MONA CHANGE REQUEST
APPLICATION REFERENCE: EN010137
IP NO MNOW-S57018

CHANGE 1

Late Submission changes and Notifications

Drawing Title:
STREET WORKS AND ACCESS TO WORKS PLANS - SHEET 11

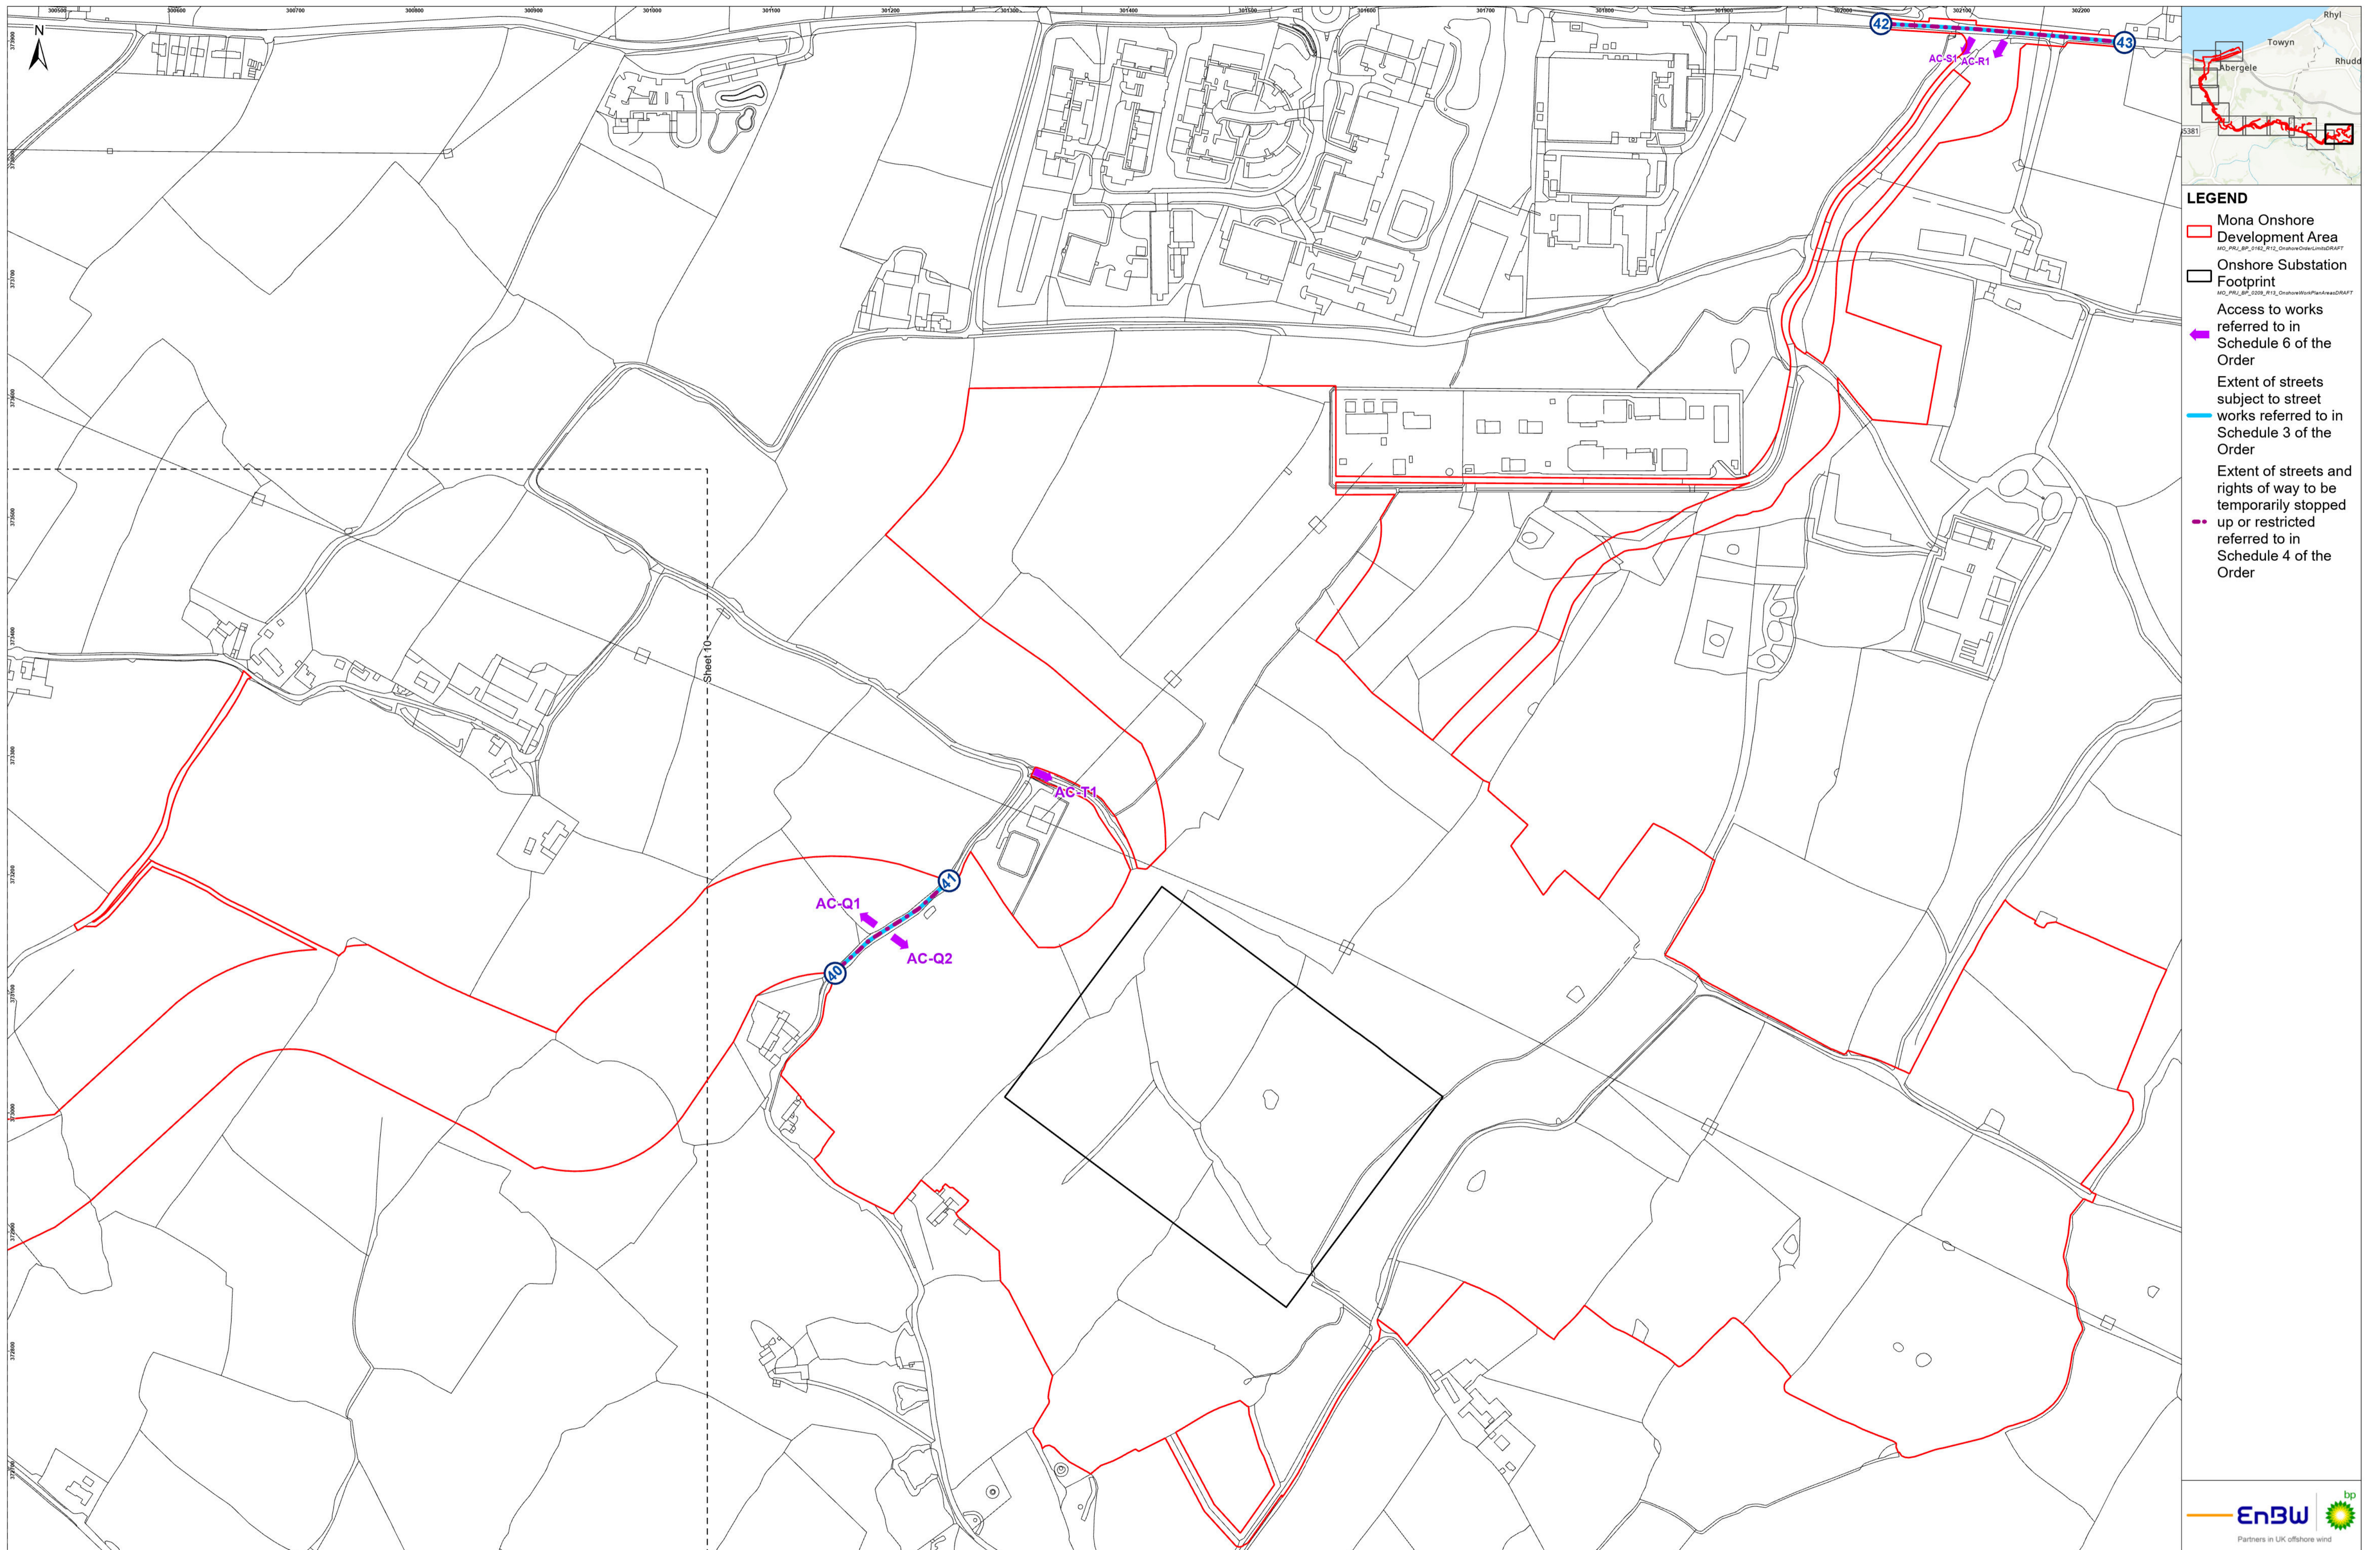
The access from Glascoed road is a narrow single track lane and a blind corner meaning it is potentially dangerous. This is particularly so for vehicles with trailers when egressing onto Glascoed road as you need to be virtually in the middle of Glascoed road to see properly. Whilst the applicant indicates there have been no collisions, the Crematorium being so close and the increase in traffic from Awel Y Môr, combined with the applicant's traffic will only increase risks.

Signage onto Cefn road highlights that it is not suitable for HGV's. I understand that the applicant states that it will not be used for HGV's but 43feet long vehicles and trailers with unspecified weight could equally be argued that the road is unsuitable.

The applicant has indicated that there are 9 passing places along 'Cefn Road' but many of those, whilst on desktop swept path analysis might appear suitable are not in practice.

Passing points 1 & 2 - These are barely suitable for a single vehicle to pull into due to open ditches on the side and vegetation,

Passing point 6 – This particular part of the lane becomes very muddy and wet during winter months and any periods of wet weather meaning that unless the passing vehicle was also a 4x4 it would not be able to pass.

Passing point 7 – This is on a blind sharp 90° bend and in order for the applicants potential 43feet long vehicle and trailer to get around the bend it will have to use all the road (and more) leaving no space for any vehicle to pass. There are also 3 other blind bends along this road providing additional safety concerns for other road users.

Passing point 9 – Gateways with open ditch on one side, again during winter and periods of wet weather, only useable by 4x4's to pass.

I don't believe it is any coincidence that the road from passing point 8 onwards has required a relatively large number of potholes to be repaired this year. We do get some potholes along this road from time to time but the numbers have increased since the applicant (and others) have been using this route for site survey and investigations.
